CITY OF ALBUQUERQUE

August 2, 2013

**Re: Murphy Express, San Mateo Blvd. and Zuni Rd.
Grading and Drainage Plan
Engineer's Stamp Date 8-01-13 (L18/D079)**

GRADING AND DRAINAGE PLAN

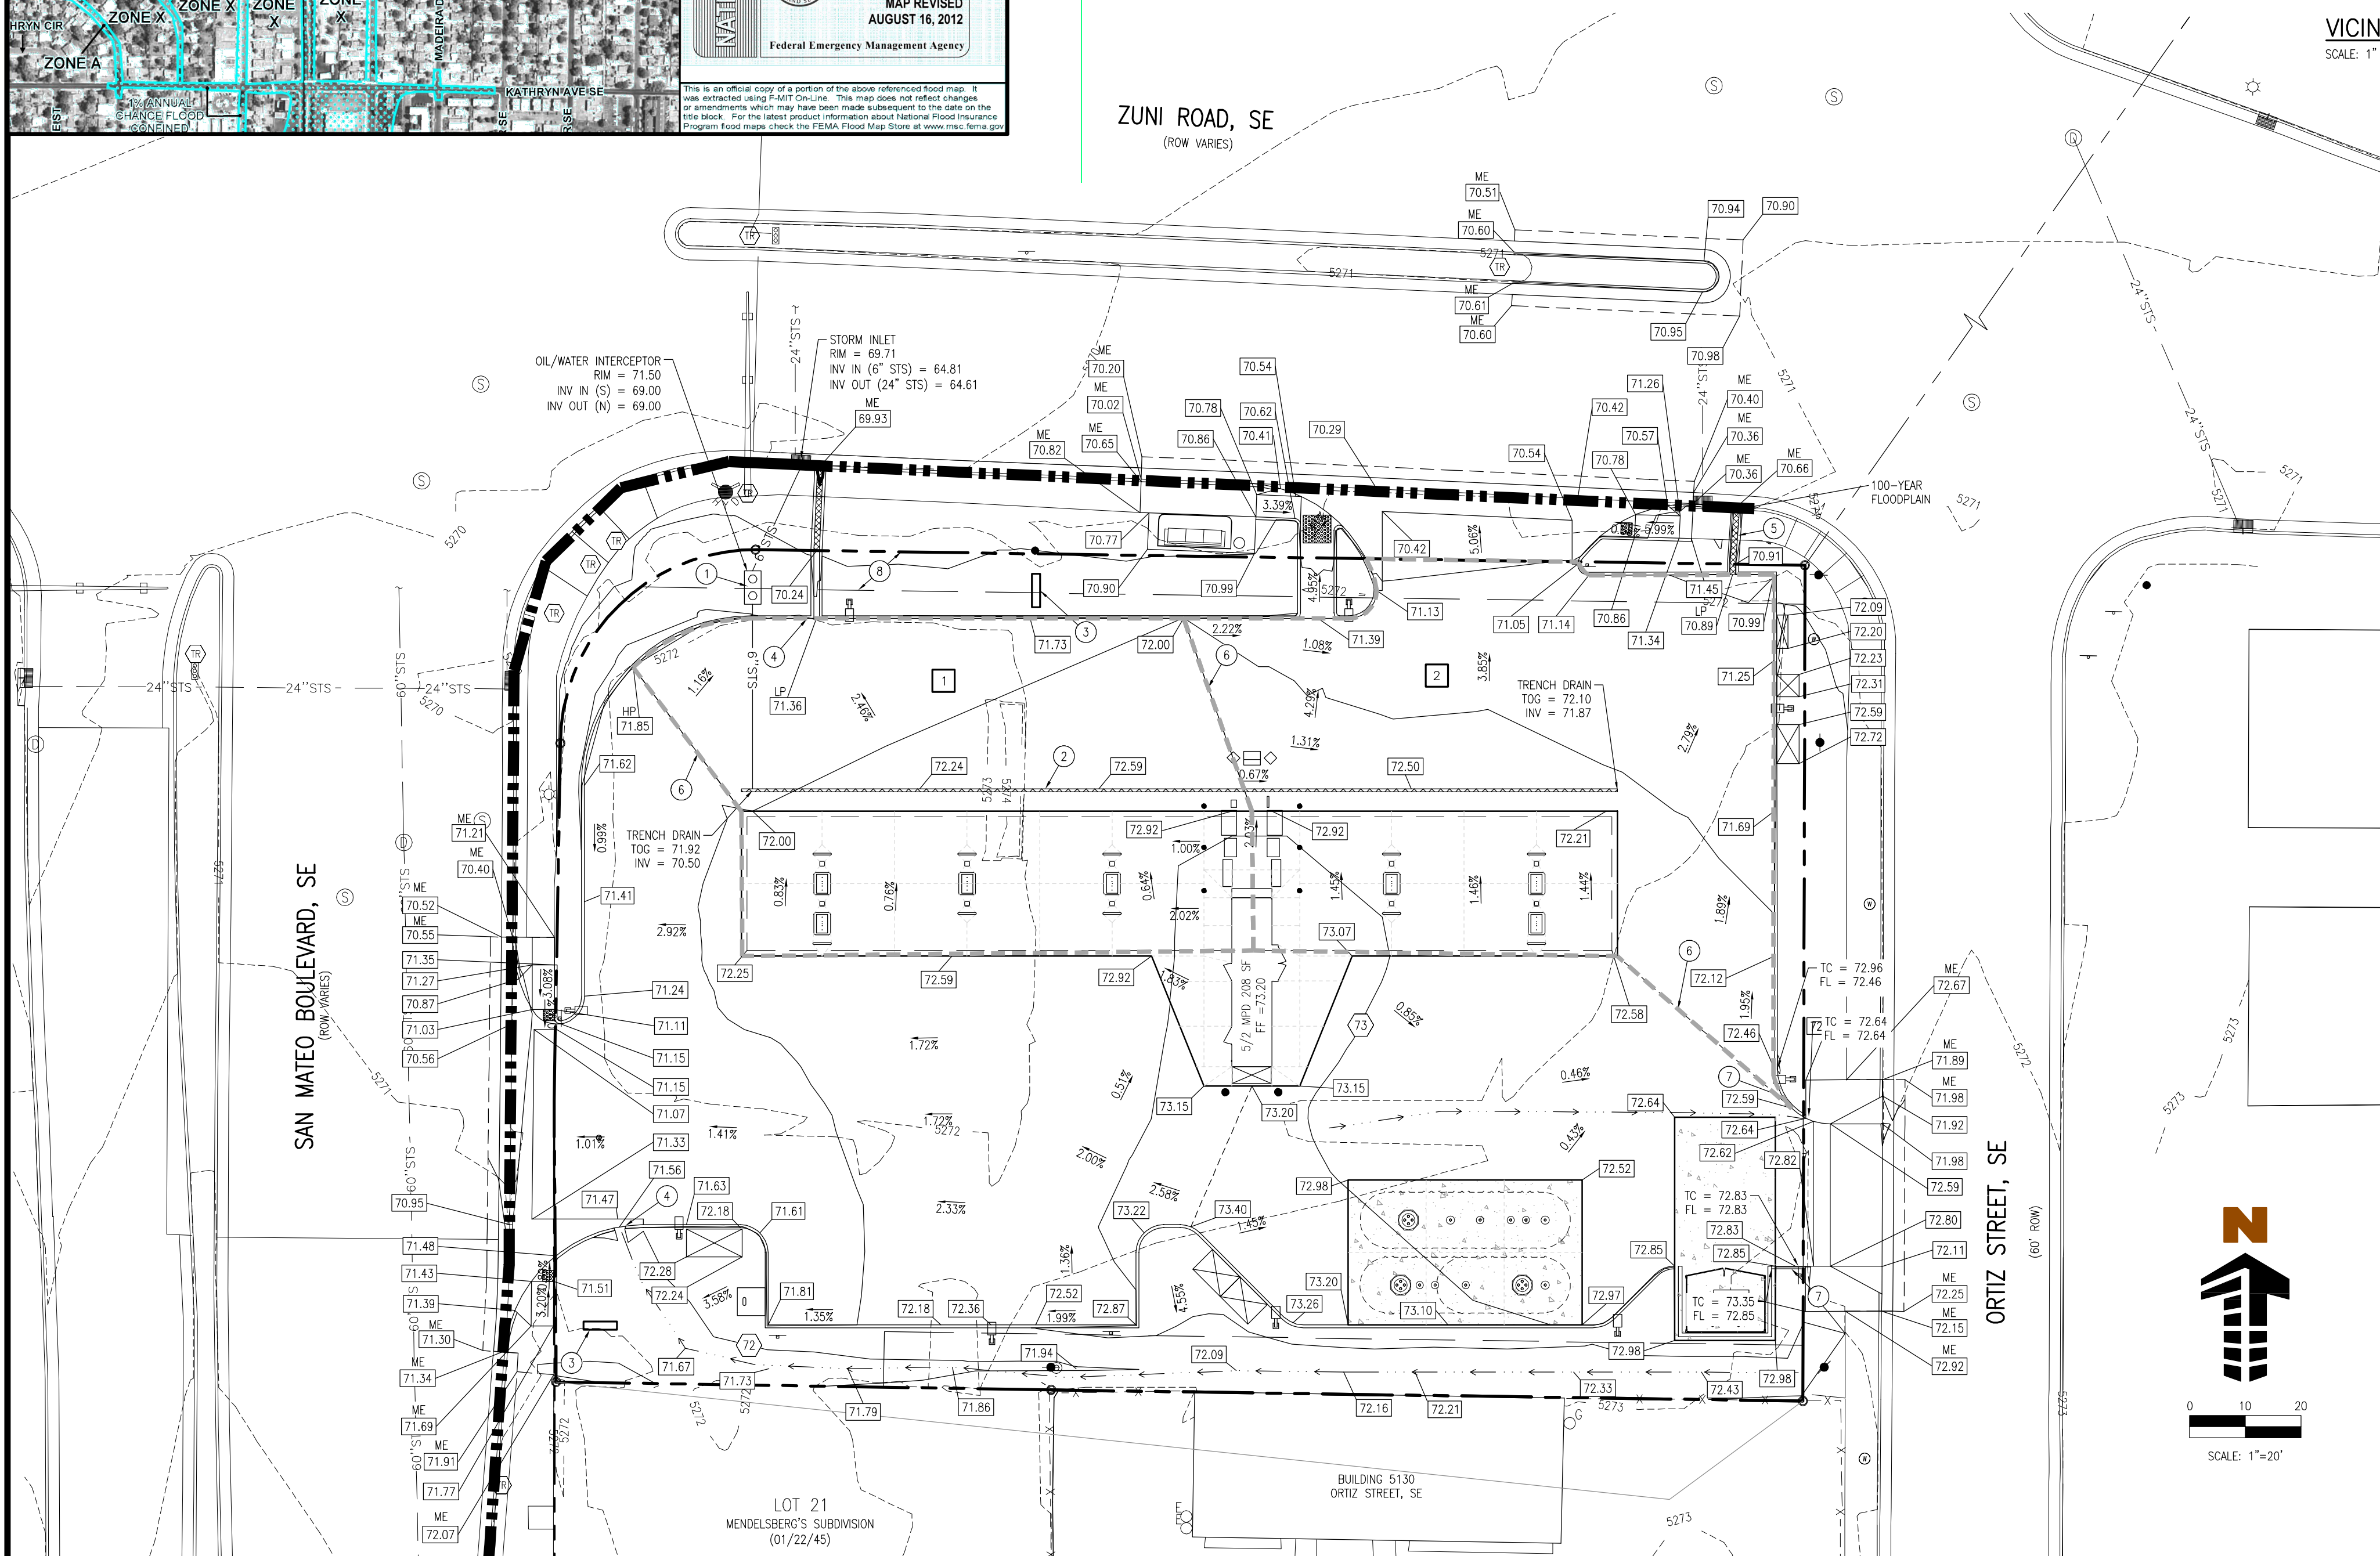
- Provide adequate as-built elevations around the pumping and near pumping areas to ensure drainage of the pumping areas to the trench drain and other areas away from the pumping areas.
- Include additional as-built elevations along the property line to assure proper drainage on-site and within the right-of-way.
